**RE: PLANS R/203/19/PL – SPRINGFIELD HOUSE, SPRINGFIELD CLOSE,
RUSTINGTON**

I object to the proposed plans for yet further alterations to this almost completed house, namely:

SECOND FLOOR PLAN

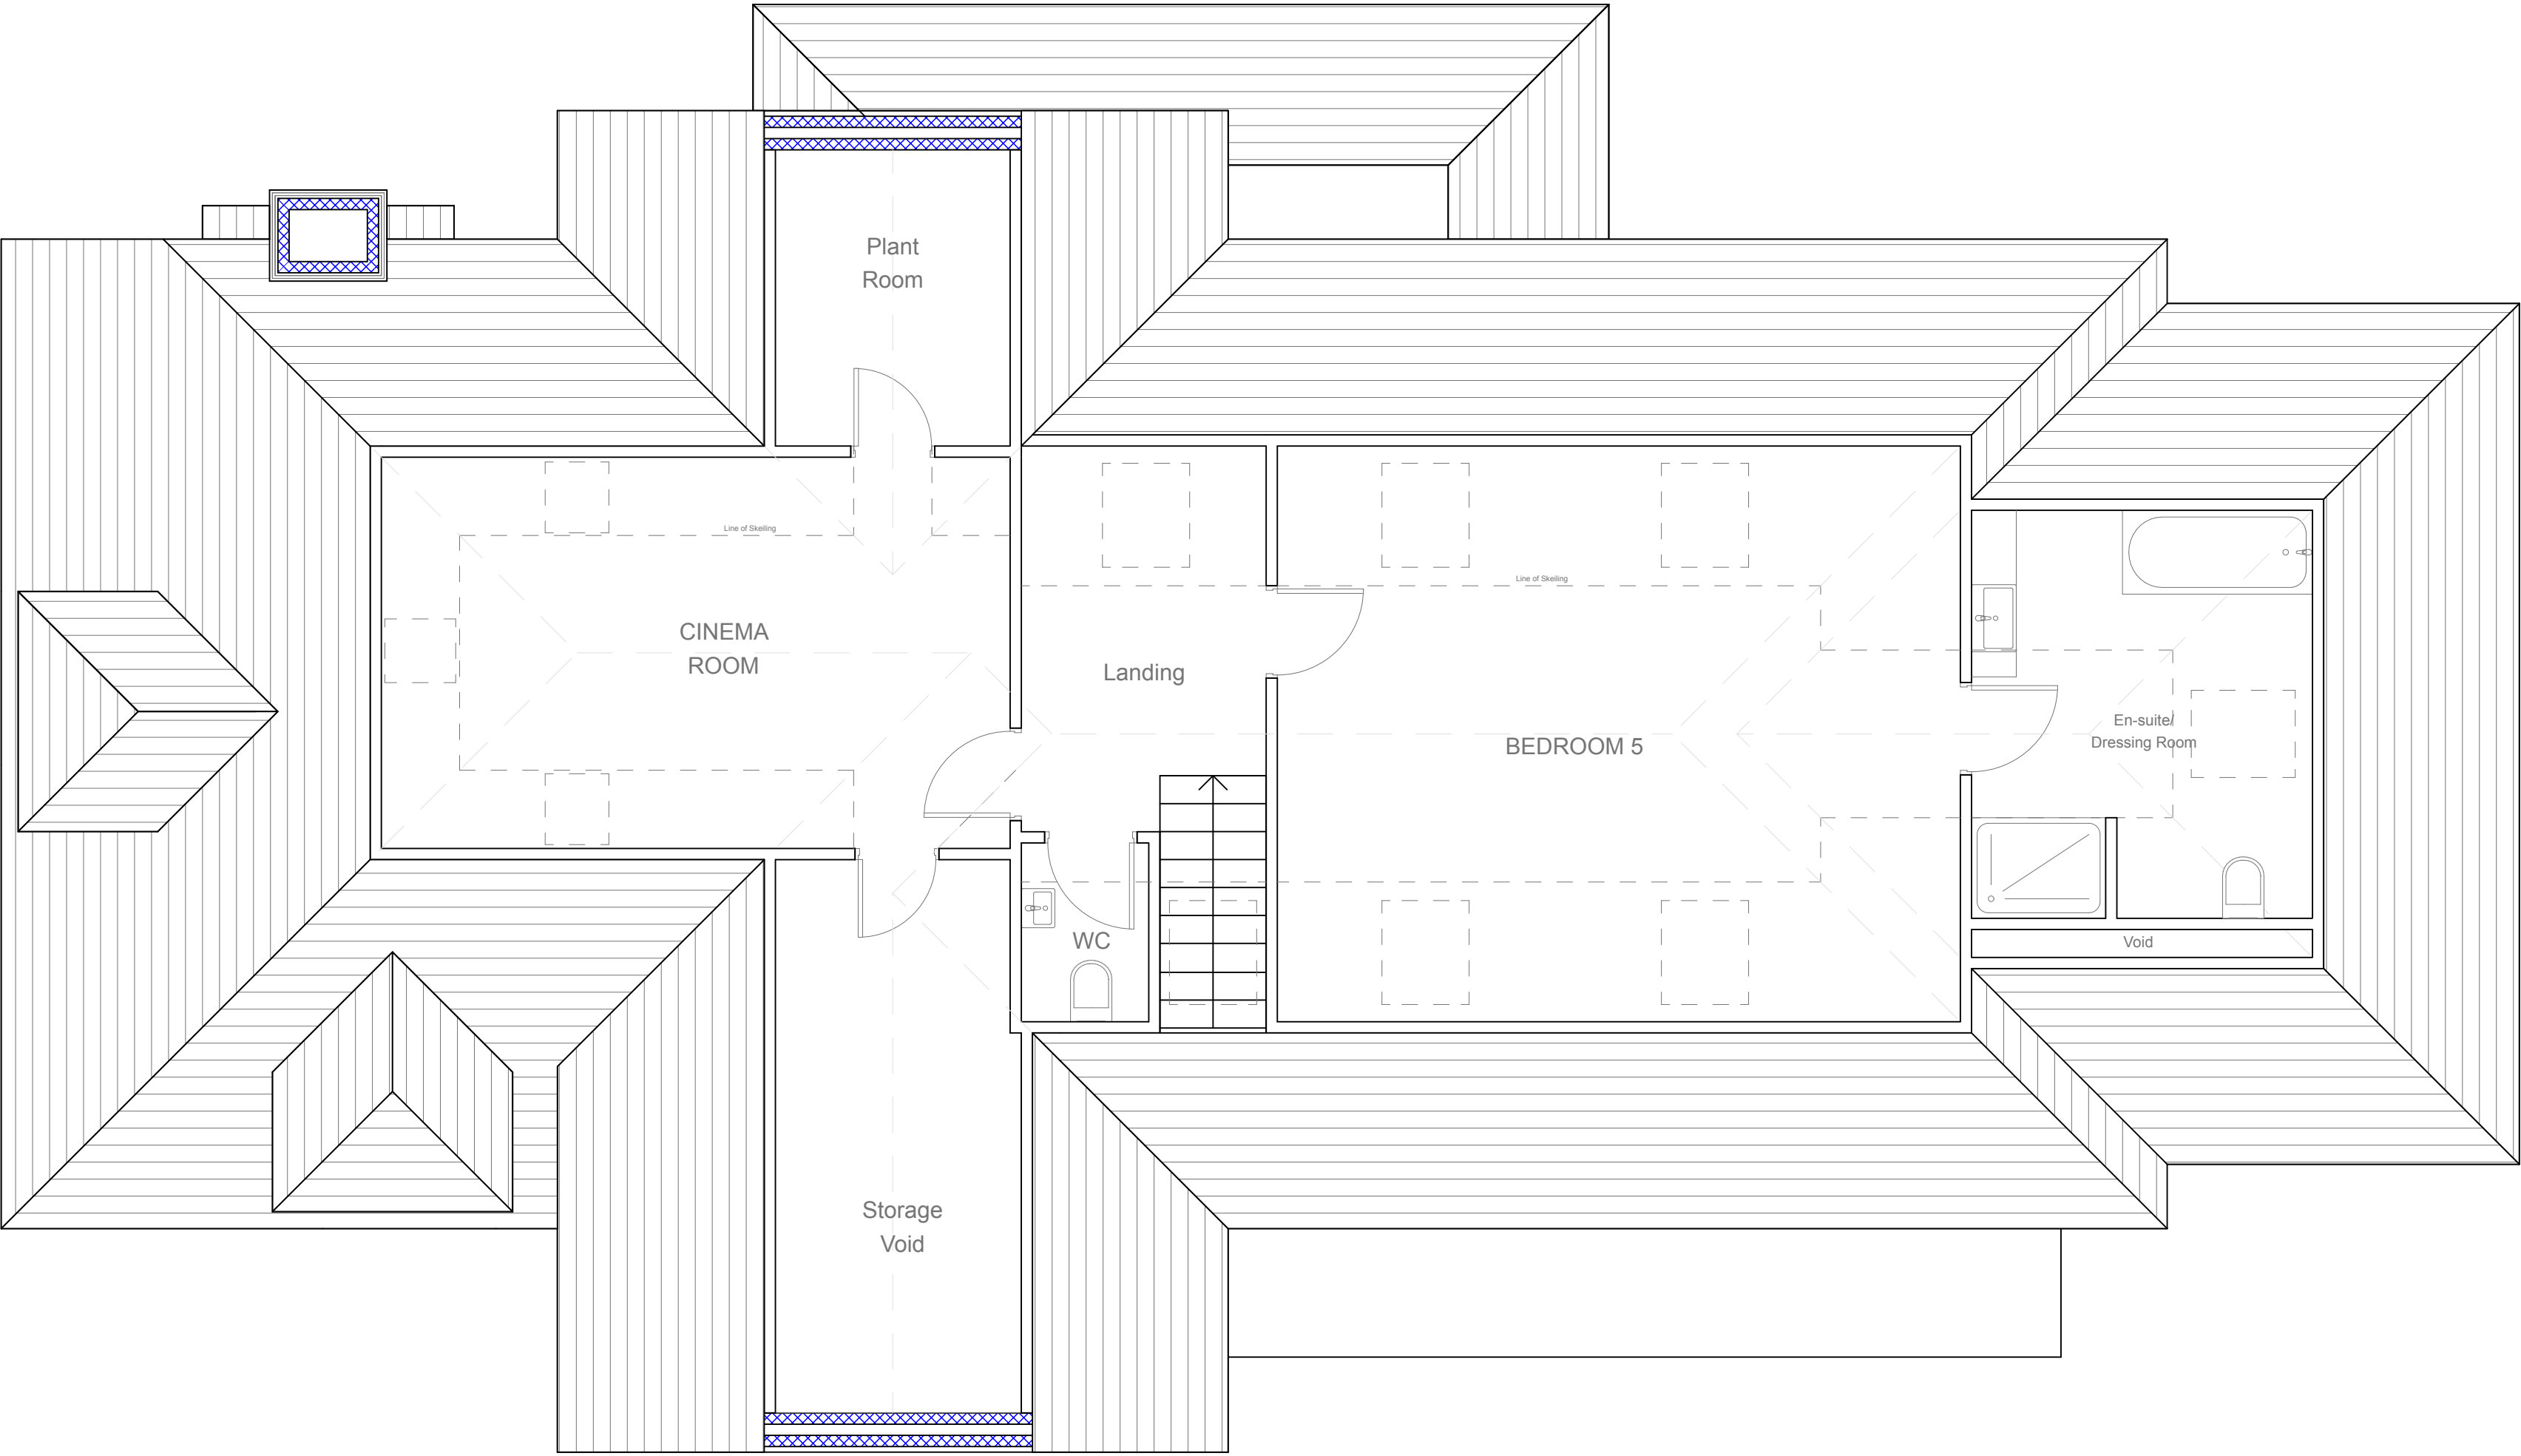
6. Any further permitted alterations requiring removal of trees to the western boundary should be declined as it will expose Pigeonhouse Lane residents to overlooking from the west-facing dormer recently added in place of a Velux window to what was formerly to be a "Plant room".

Job Title	Springfield House		
Client	Castle Property Developments		
Drawing Name	Garage - Plan & Elevations		
Drawing Status	Planning		
Drawn by	DF	Date	Sept 19
Checked by		Date	
Drawing Scale	1:50 & 1:100 at A1		
Drawing No	Status	Revision	
181303/	09

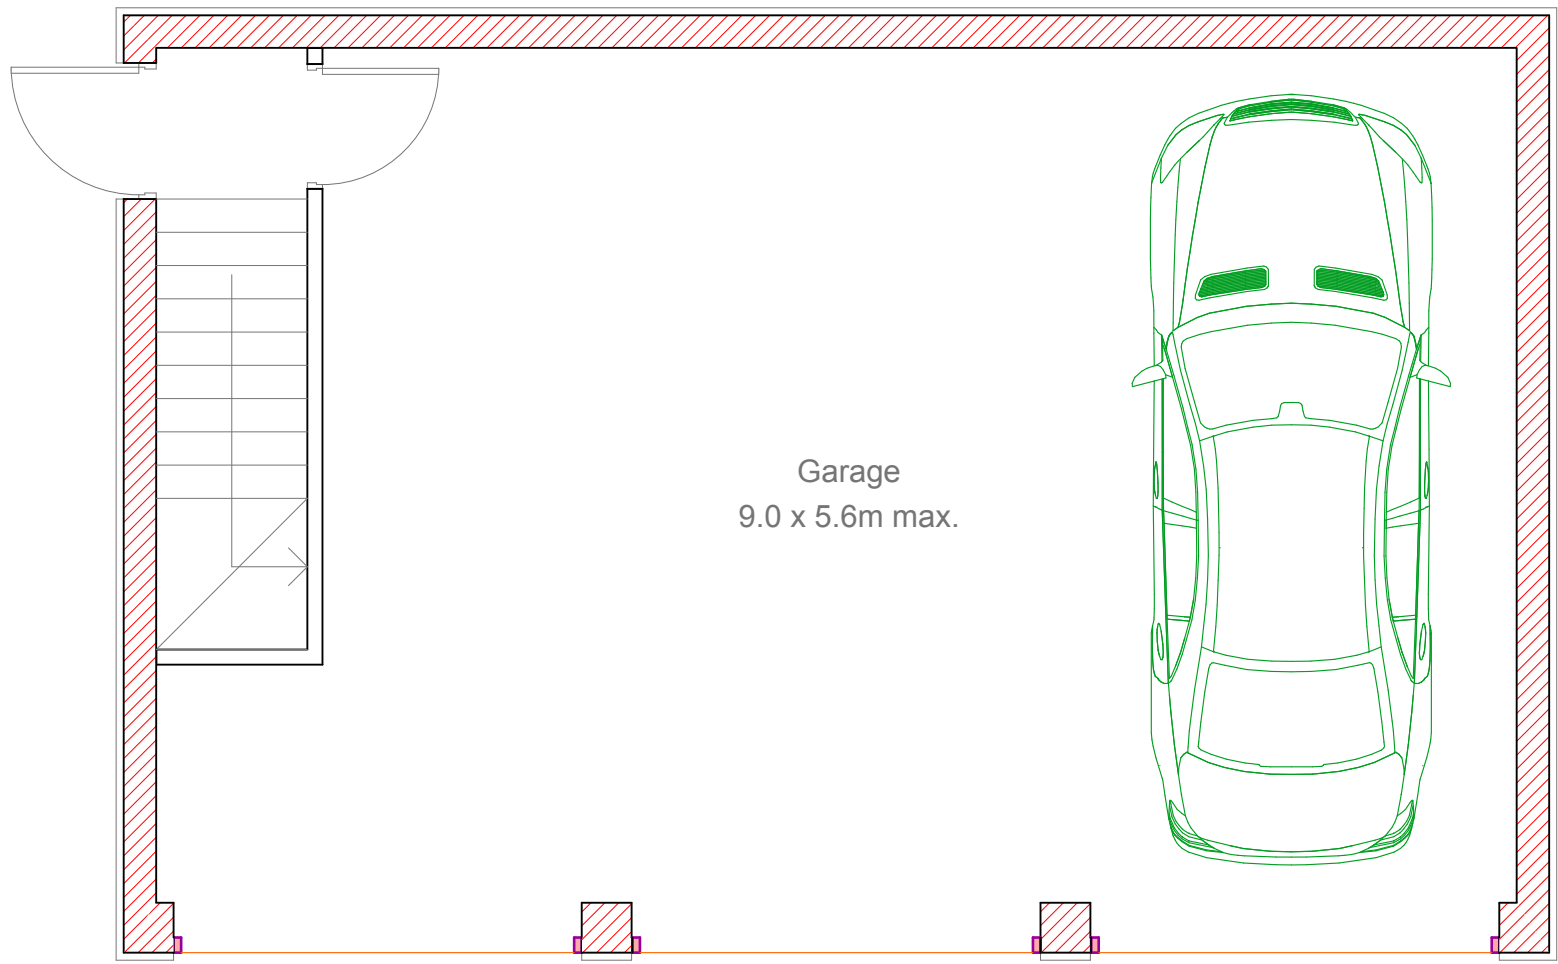
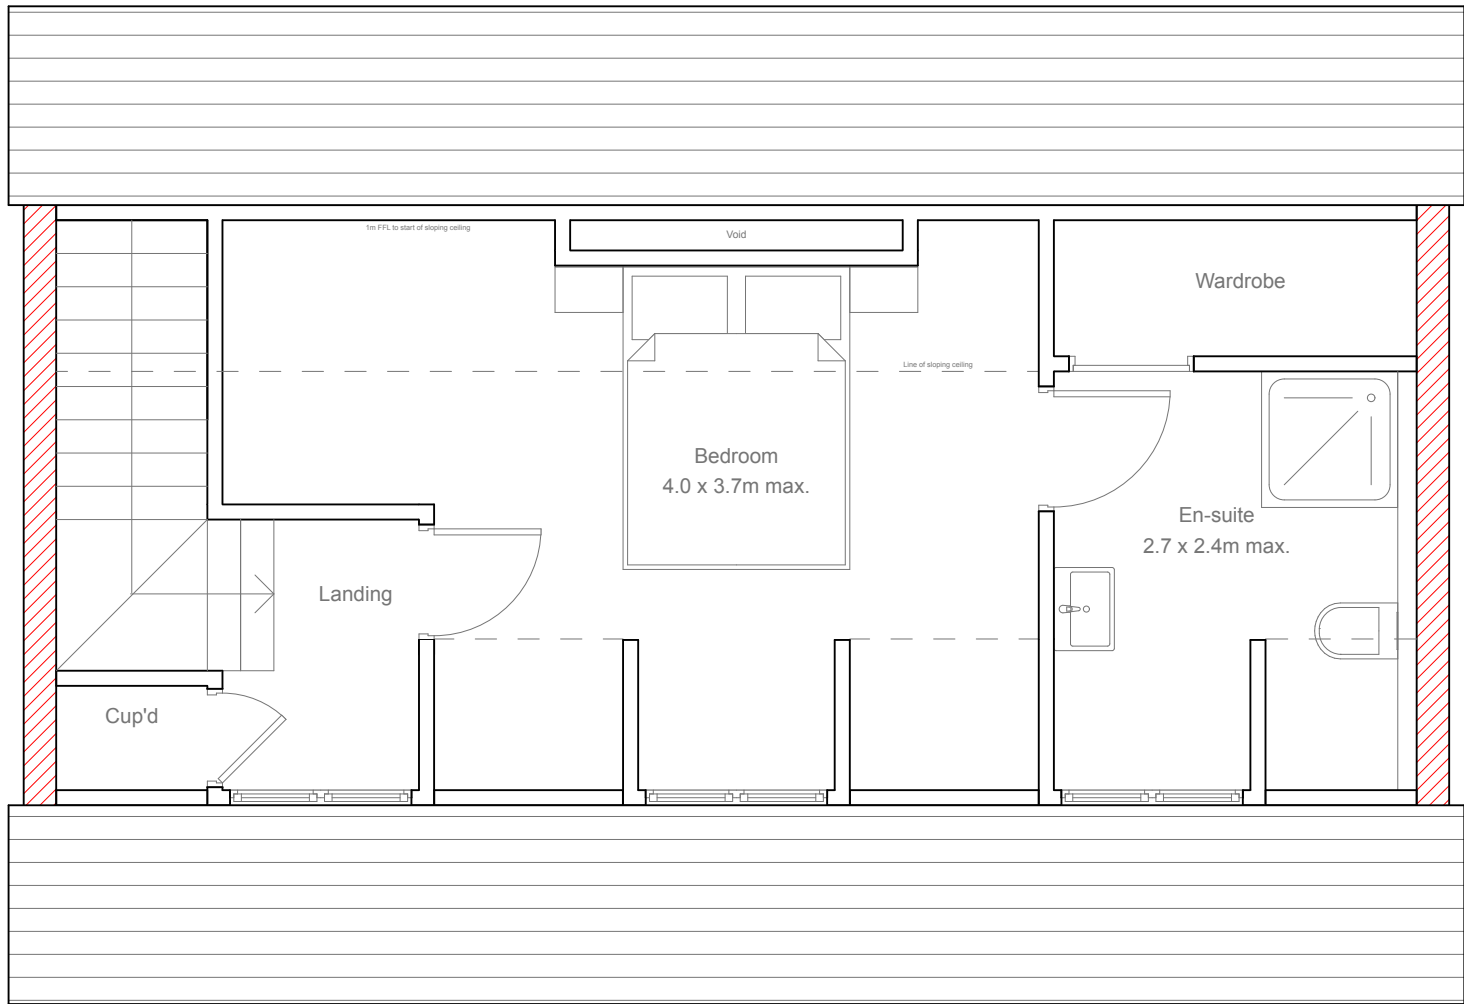
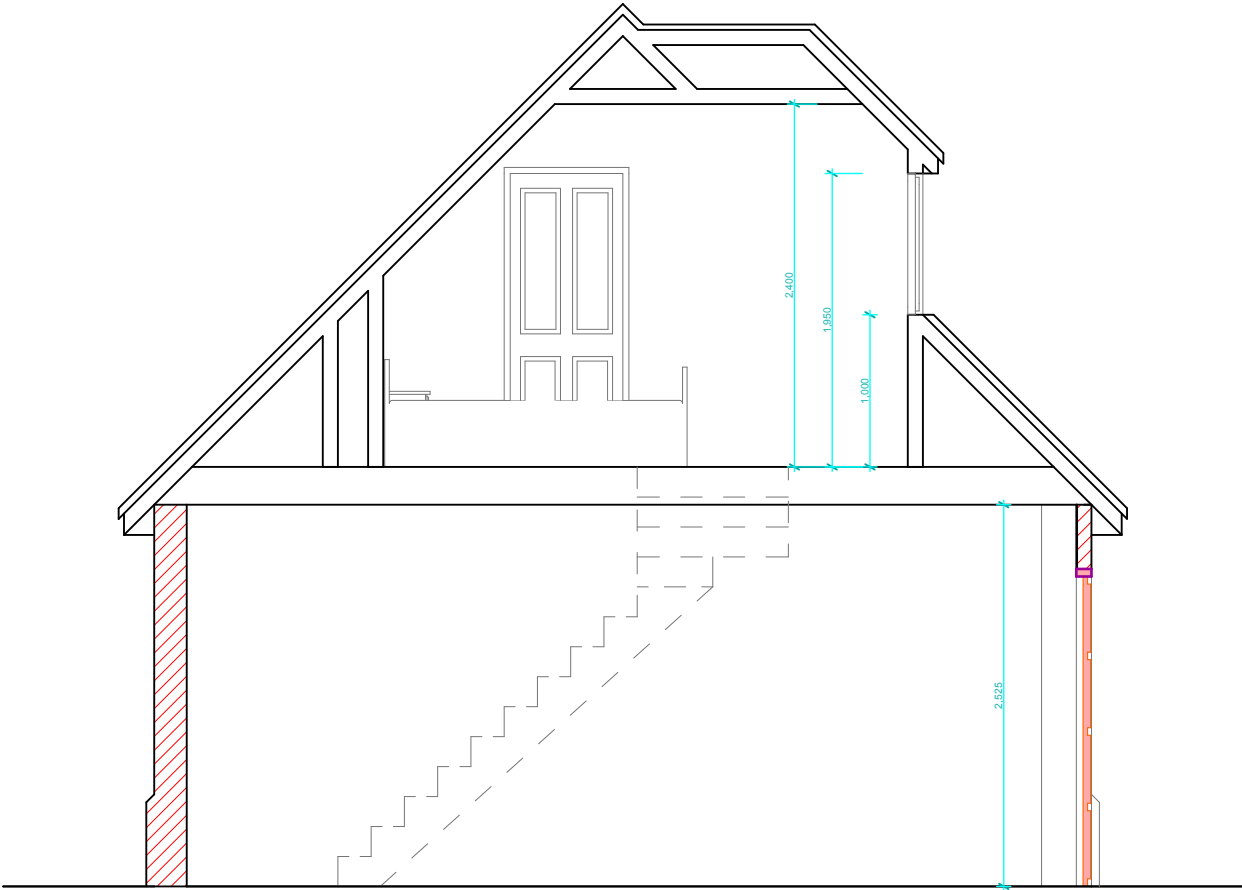
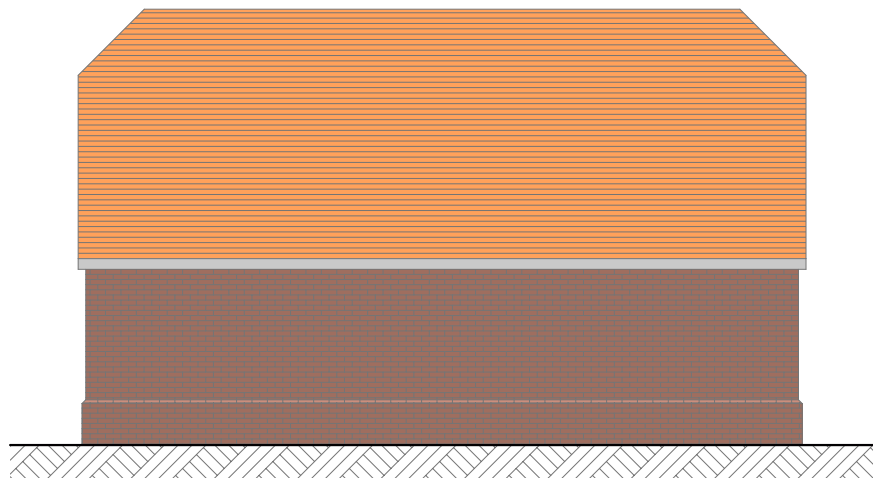
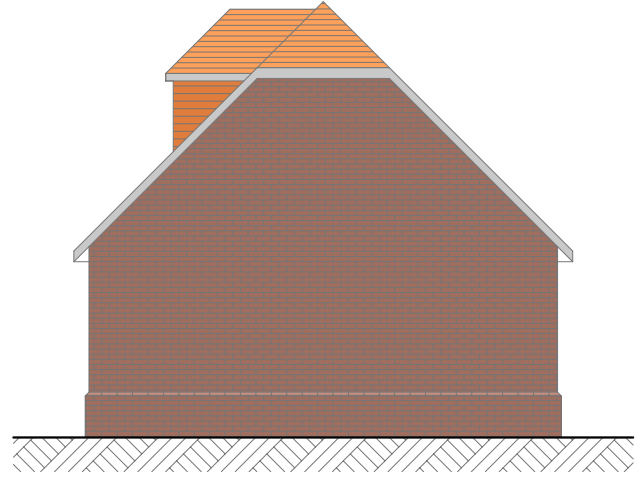
5. The much larger garage facilitating unwarranted accommodation above for this already much increased development will only adversely add to the visual impact upon neighbouring properties, especially if further screening is removed.

Title			Proposed New Foul Drainage		
Scale	1:500	At original	A4	© Robert Clark Associates Ltd	
Drawing Number	1772/F/SK2		Revision		-

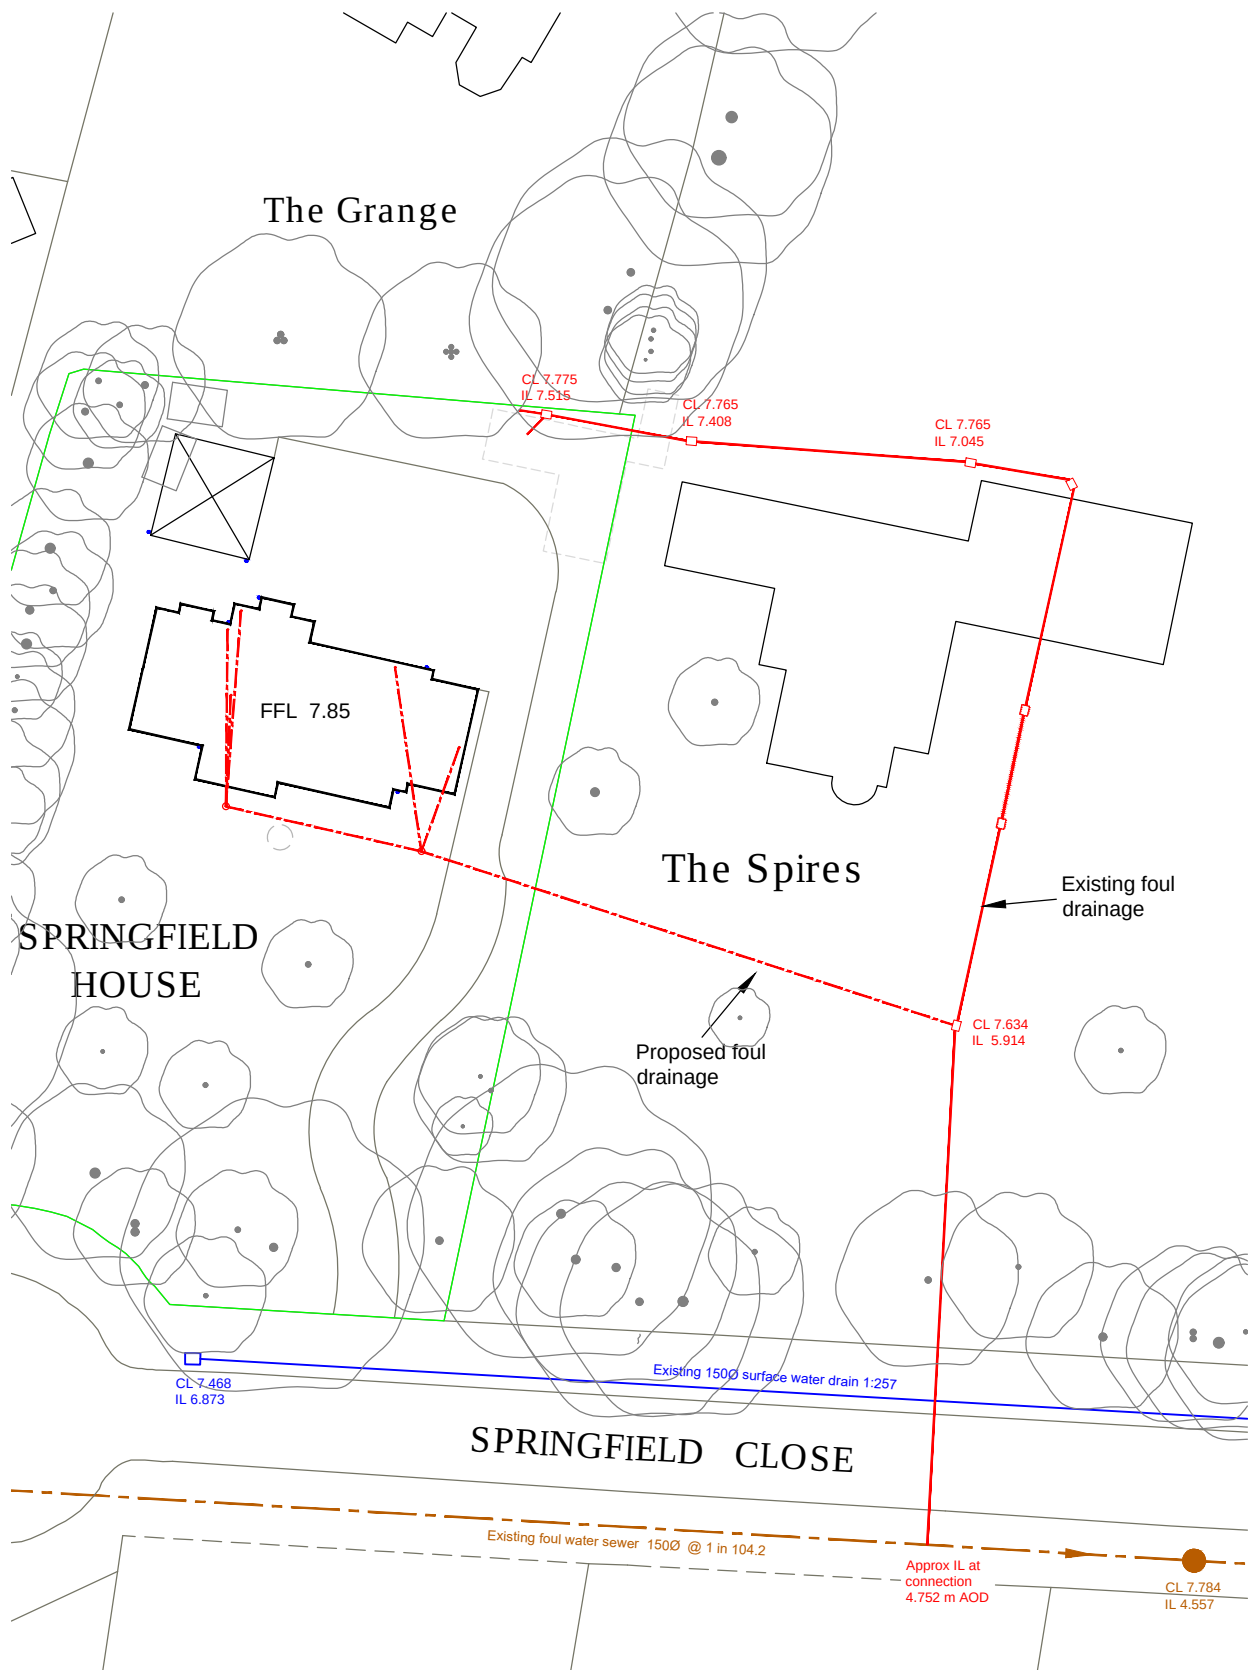
4. The Drainage Engineer's assumption that the pool will be open with overflow and backwash going into the foul sewer seems unfounded and of concern when reading that the foul drainage fall is to be only 1 in 80 instead of the more usual 1 in 29. This surely increases the risk of blockage and a build-up of waste that could result in foul water being unhealthily added to any localised flooding.
